Re: Albuquerque ER & Hospital
4315 Wyoming Blvd. NE
Traffic Circulation Layout
Engineer's Stamp 11-09-21 (G19-D004D)

Based upon the information provided in your submittal received 11-16-21, the above referenced plan cannot be approved for Building Permit until the following comments are addressed:

SP-1

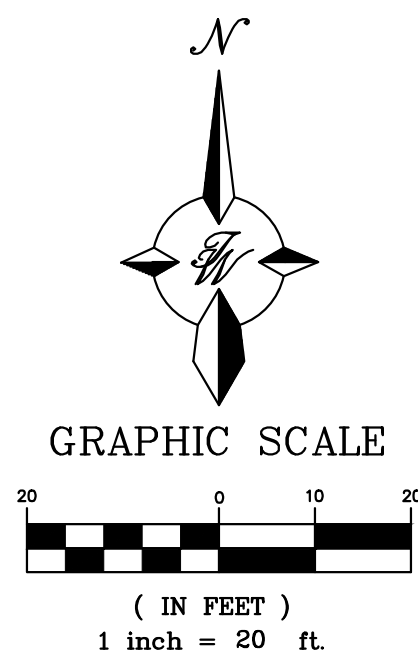
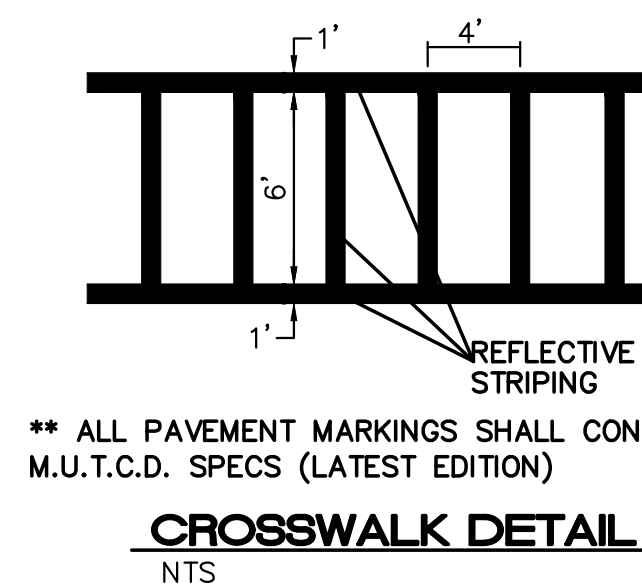
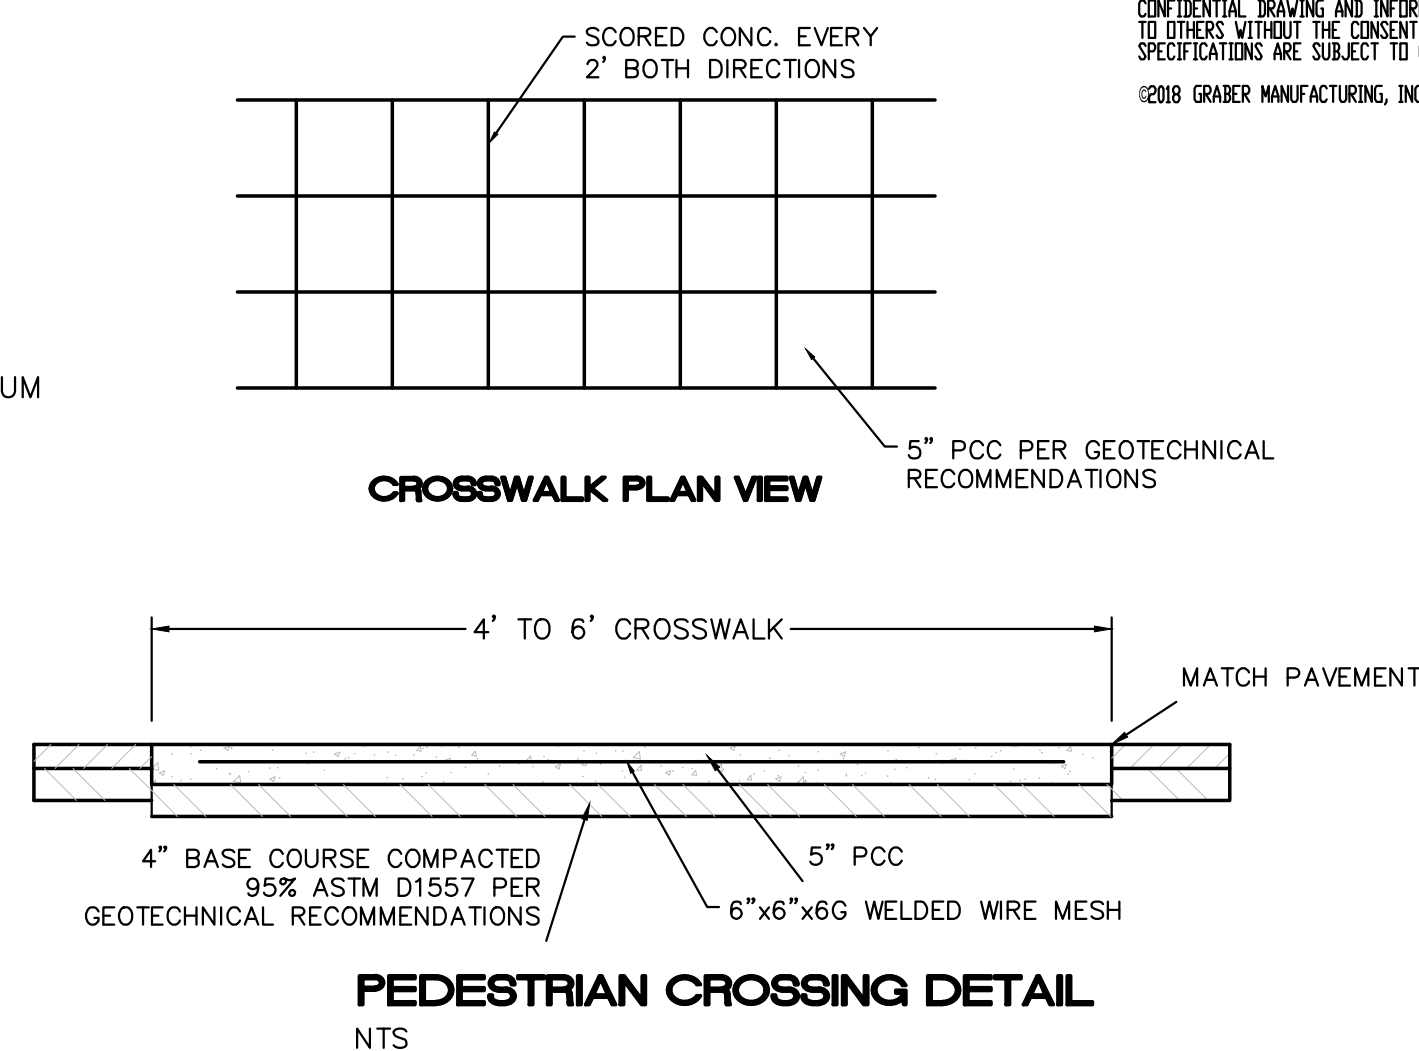
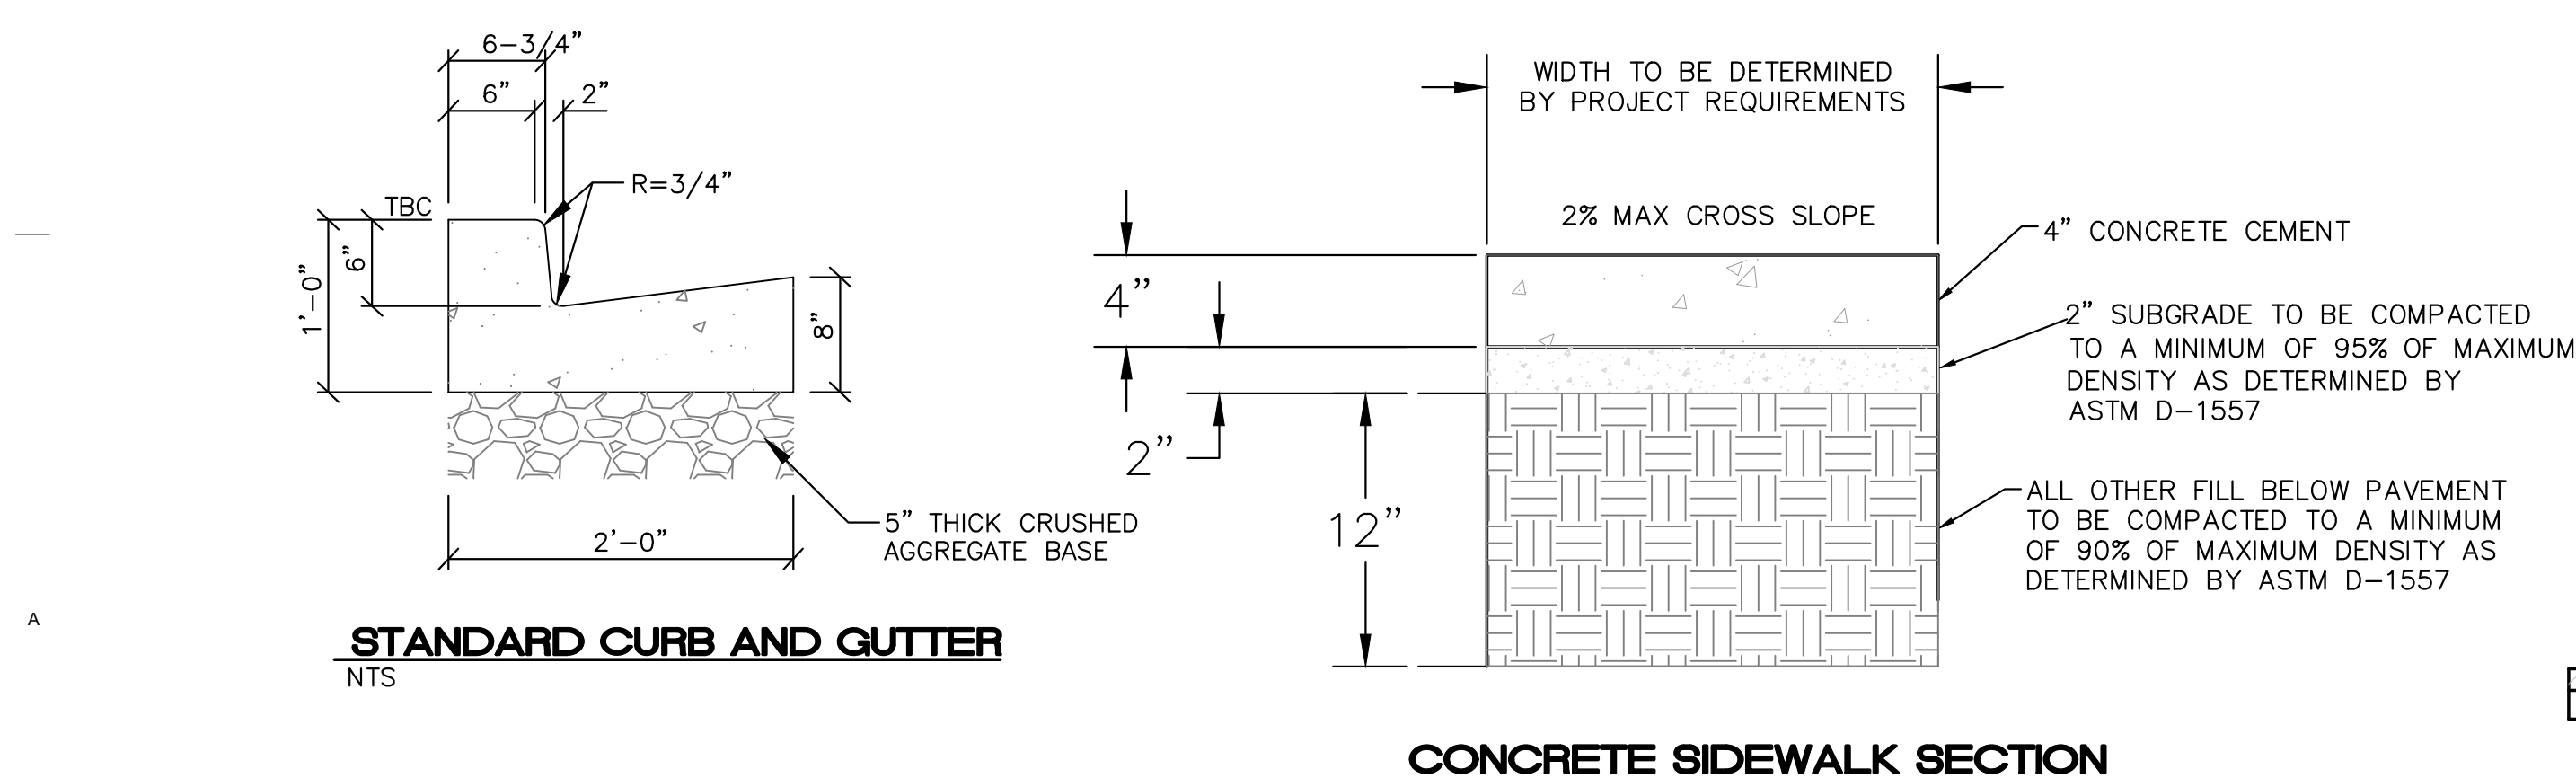
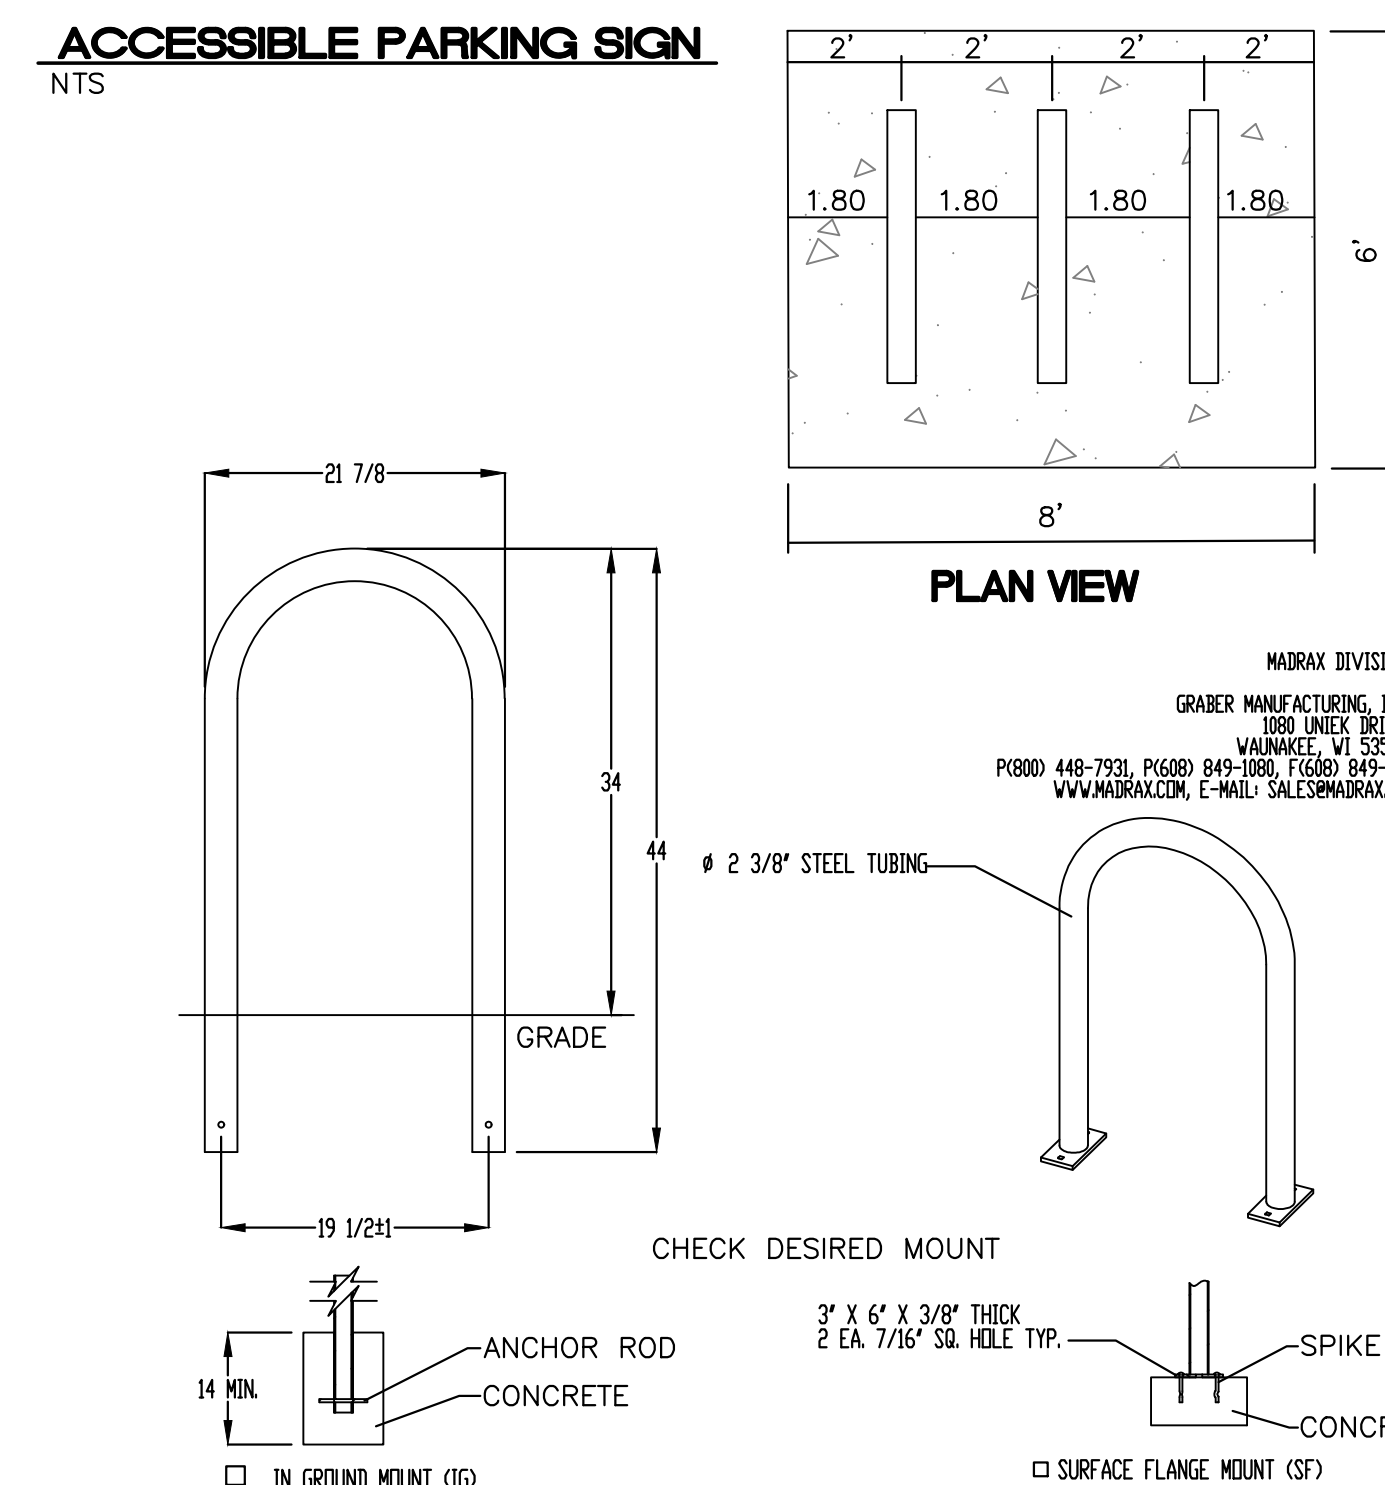
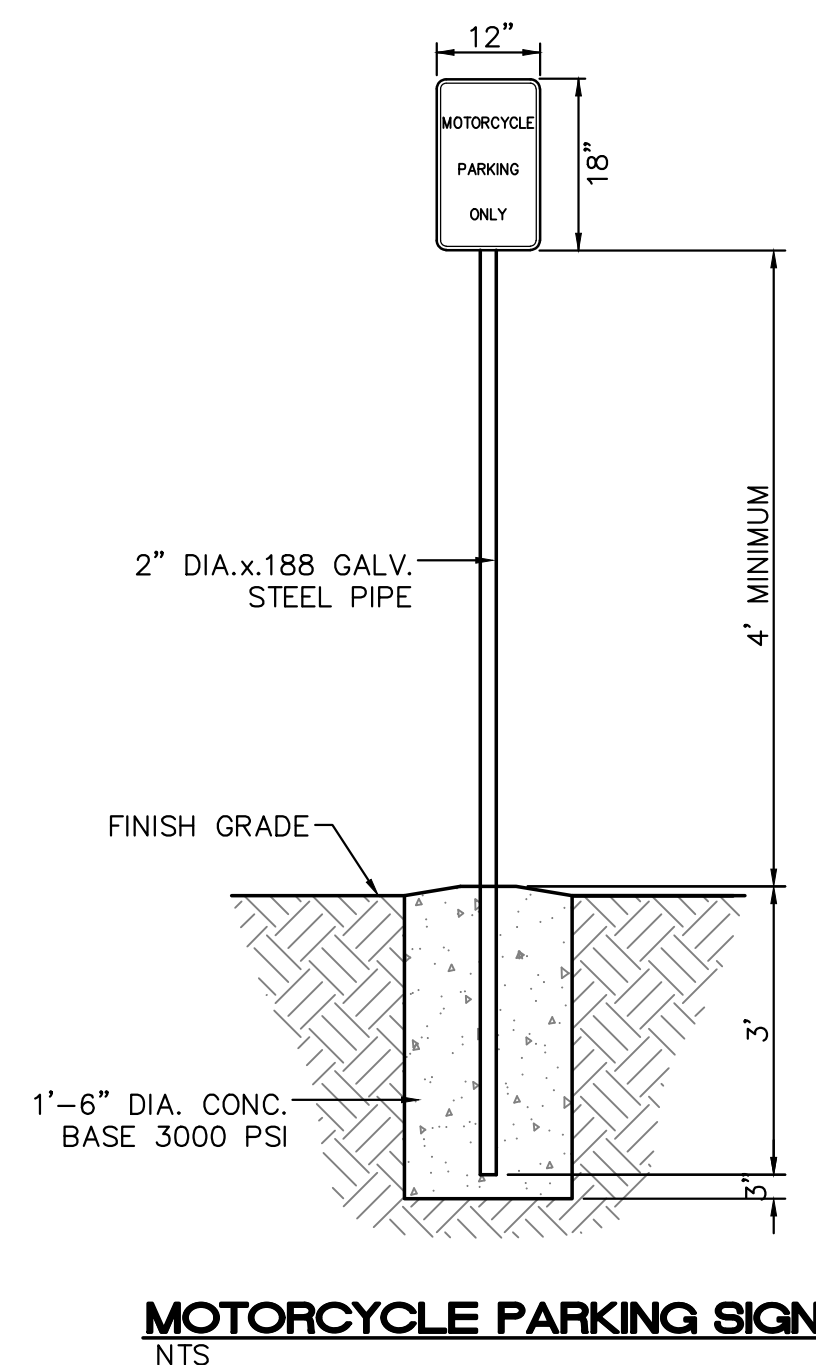
1. Key note 18: Proposed driveway access Ramp on-site plan is not per COA standard DWG. Please modify the site plan.
2. Site plan showing that ADA Van access aisle is 8', but the details sheet shows 7'. Please address this concern.
3. The ADA accessible spaces must include an access aisle. Van accessible aisles should be 8ft wide; all others should be 5ft wide.
4. ADA Van accessible aisle: Per DPM, a 6 ft. wide ADA accessible pedestrian pathway is required from the ADA parking stall access aisles to the building entrances. Please clearly show this pathway and provide details.
5. ADA Parking space: It appears there will be a conflict between the overhang vehicle and the proposed ADA sign. Please address this concern.
6. Provide Fire Marshal Approval.
7. Provide a copy of Approved Preliminary Plat. (This is a condition for approving TCL)
